APPLICATION BY NNB GENERATION COMPANY (SZC) LIMITED FOR AN ORDER GRANTING
DEVELOPMENT CONSENT FOR THE SIZEWELL C PROJECT

AMENDMENT TO THE APPLICATION AND INCLUSION OF ADDITIONAL LAND

Submission to Planning Inspectorate on behalf of Suffolk Building Preservation Trust concerning the impact of proposals regarding Pakenham Fen and the operation of the historic Pakenham Water Mill

Figure 3.13a
Fen meadow compensation potential for Pakenham Fen north site

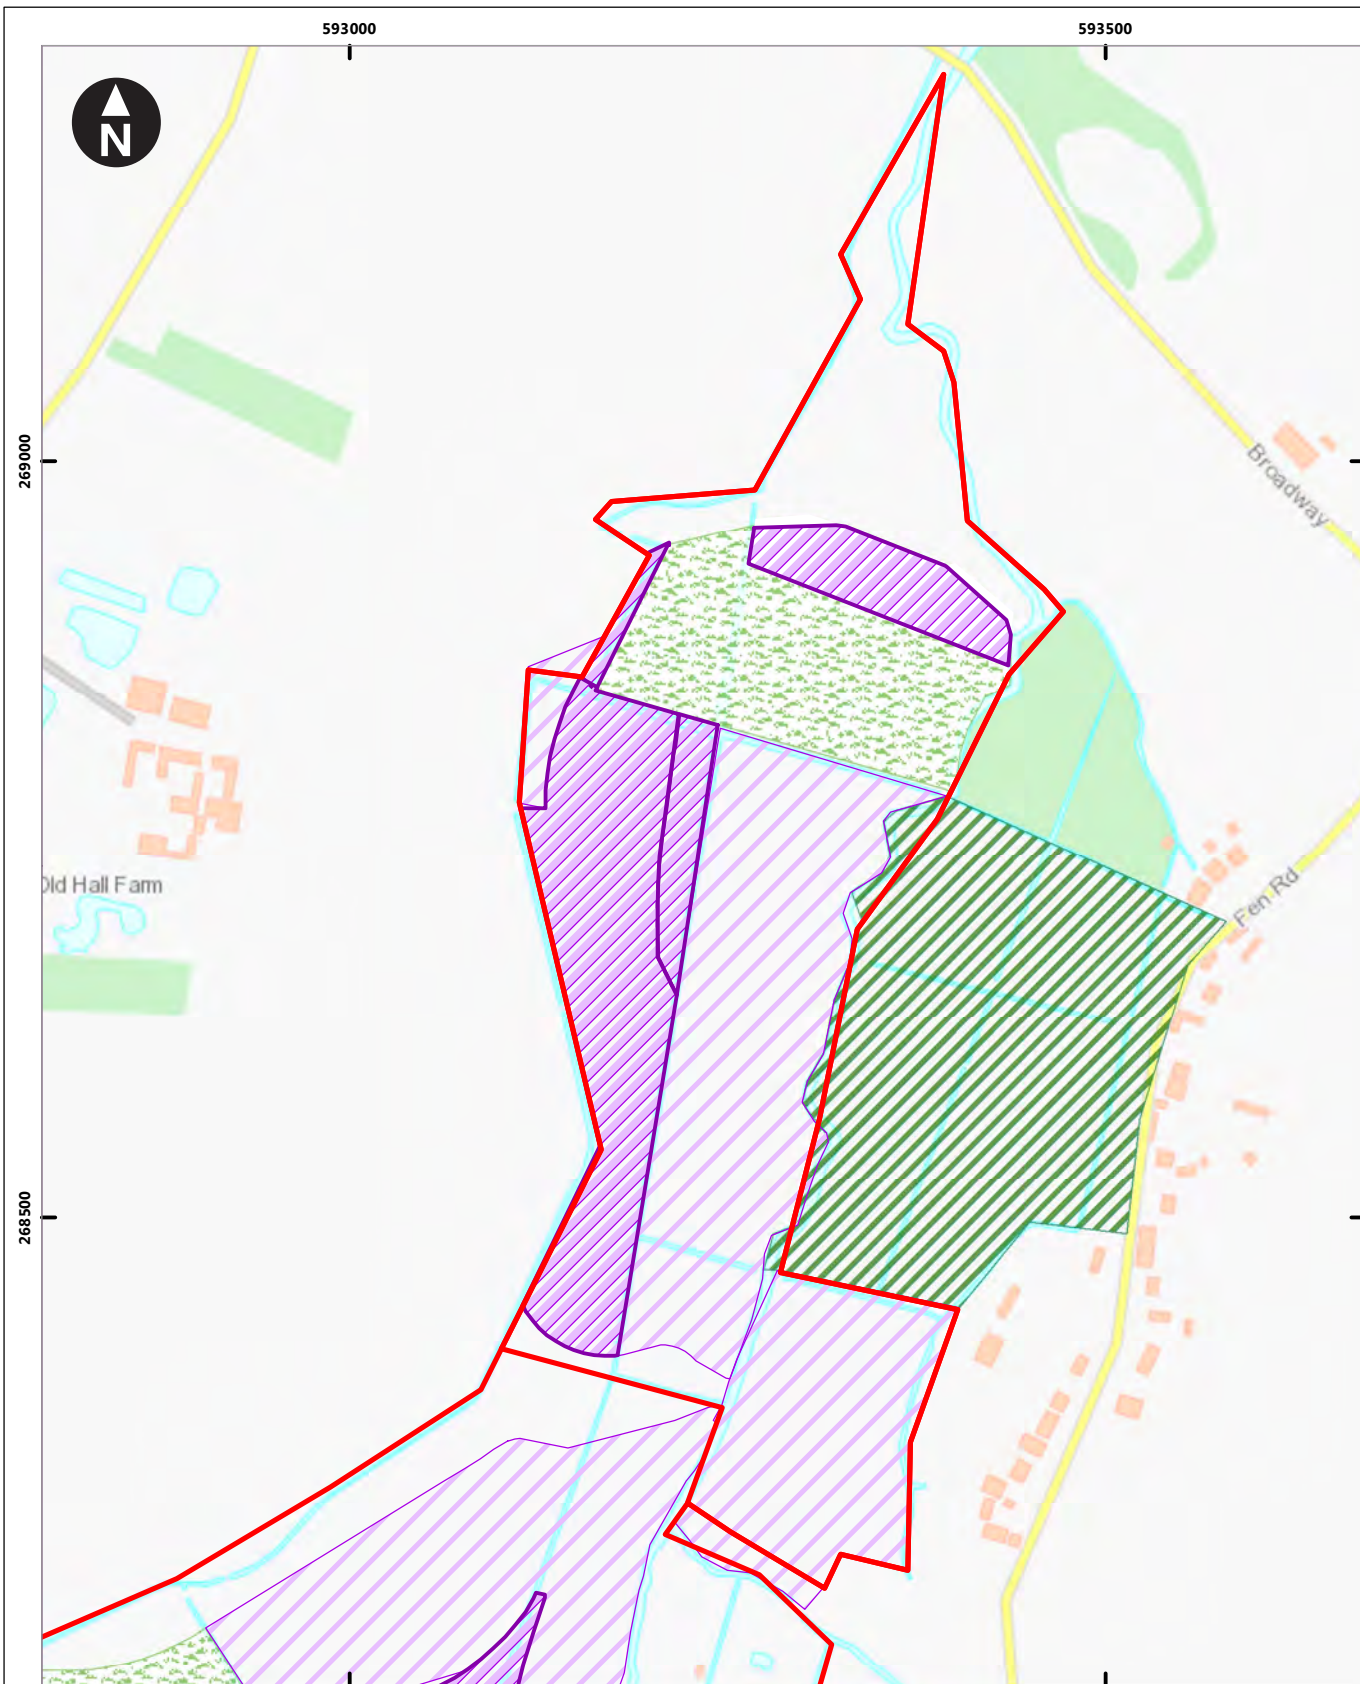
11. The proposed area for the fen meadow development is shown running along the boundary of Pakenham Stream (Figure 2), which feeds the mill pond. Any alteration to the adjoining land could have an impact on the supply of water to the Mill.

12. For the fen meadow to function it will require a supply of water, over and above what is on the land today. If this were not the case, then the land would already be a fen meadow. The land in question is in an intimate upstream relationship with the Mill and it is reasonable to assume that the land drainage that has evolved over millennia has taken the Mills requirements into account. Indeed, historically, it is likely that it was in the interests of all land managers to ensure that the Mill could function. The reference in the Enclosure Act demonstrates this position. This historic perspective, well known to the Trust, has not been investigated by EDF.

13. An increase in the supply of water to Pakenham Fen can be achieved in two fundamental ways, either by diverting water from Pakenham Stream, or by lowering the ground level in order to access shallow groundwater.

14. Diverting water from Pakenham Stream will have a direct impact and increasing access to groundwater will have an indirect impact, on the water supply to the Mill. Increasing losses from groundwater, either by increased uptake by the plants, or by diverting it to the "lower stream" has a high probability of reducing late spring, summer and early autumn flow in the "upper Stream" (Pakenham Stream). The magnitude of this impact has not been assessed by EDF.

15. Work done by EDF and their consultants has concentrated on the ecological suitability of the fen, with water supply aspects only covered at a very high level using inappropriate broad, large scale models which are not designed for this type of application. The assessments do not take account of the critical, local water management balance that exists in the area.
